Ref: EN020026

Application by National Grid Electricity Transmission (NGET) for an order granting development consent for the South East Anglia Link (Sea Link) Project

Examining Authority's Third Written Questions (ExQ3) Issued 24 March 2026

Plate 1.1 Cable route overview showing stakeholder areas of concern in relation to water depth

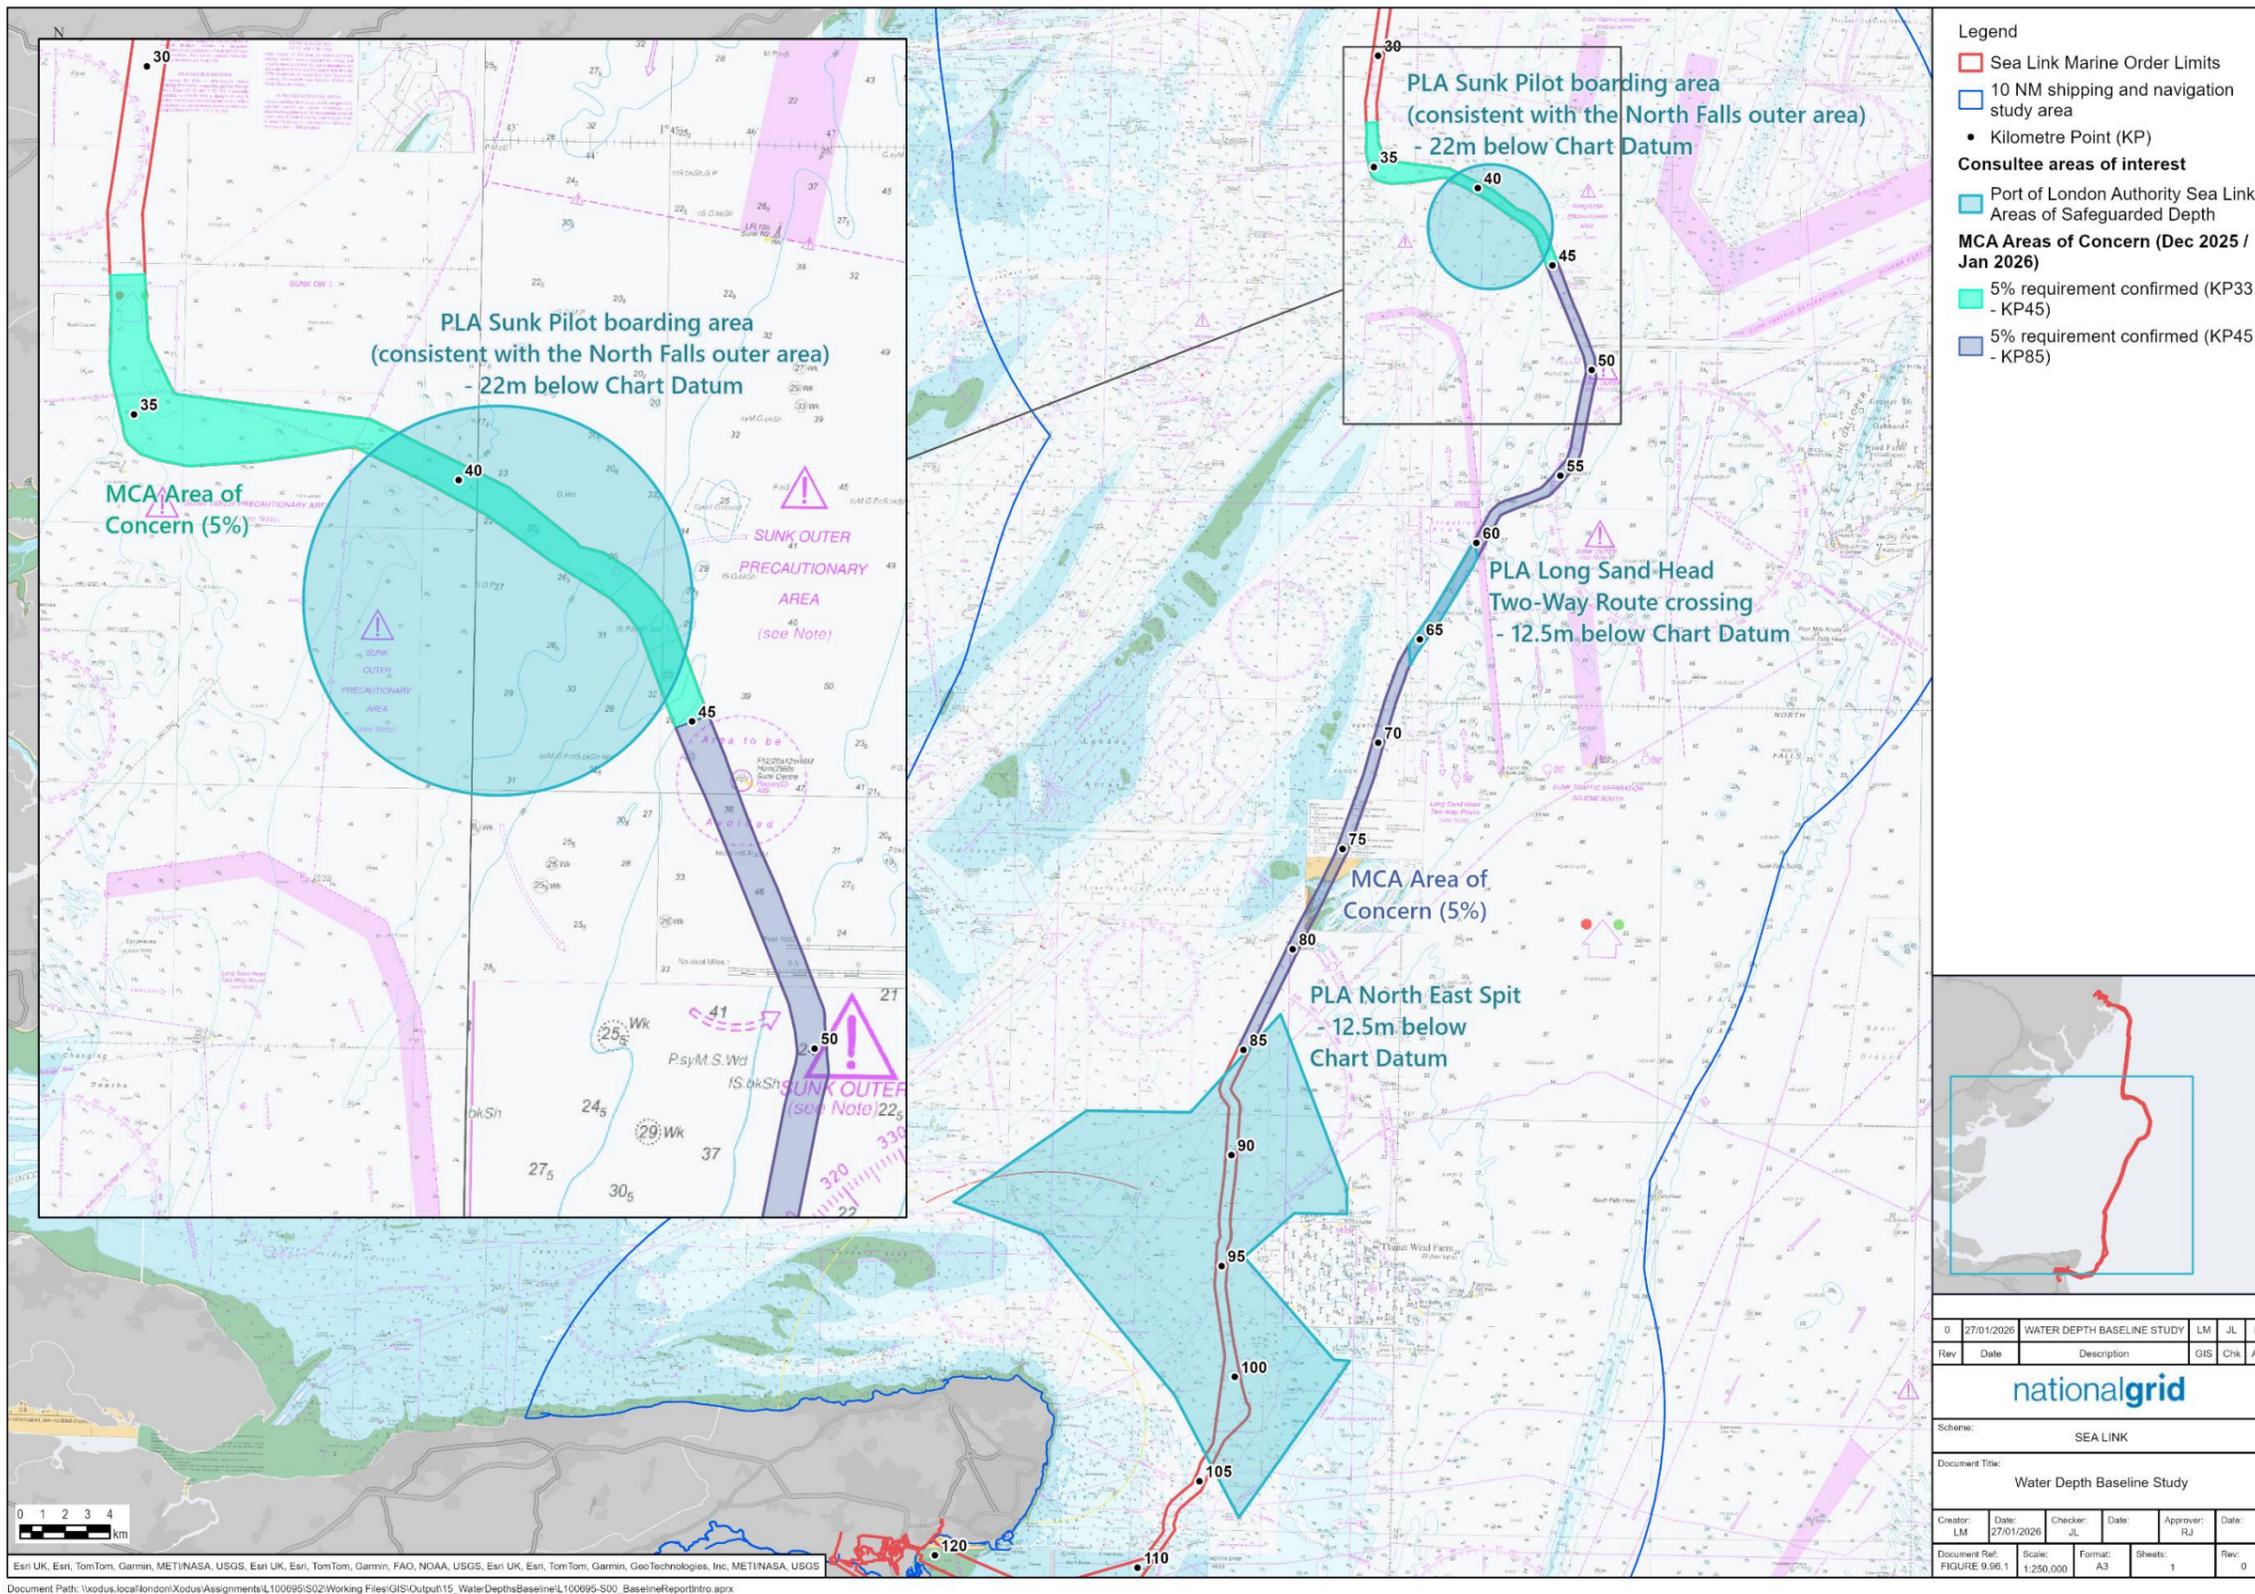
Water depth Baseline study – Technical Note REP5- 120	need amendment to reflect DML condition 4 (6).	
4) DCO	SOCG – 3.2.2	<p>Inconsistencies in numbering with references to DML conditions- e.g. 5% is referred in condition 4(5) of the DCO and it should be 4 (6), and no depth reduction between KP 33 & 38 is referred in 4 (6).</p> <p>Part 6 (2) of DCO references the NIP in 4 (k) and it should be 4 (1) (g)</p> <p>To ensure no concurrent RAM activities take place within the MCA area of concern, the addition of this Condition which was provided as a post meeting note for MCA/Sealink</p>	Inconsistencies within the DCO can cause the conditions to not be correctly fulfilled.
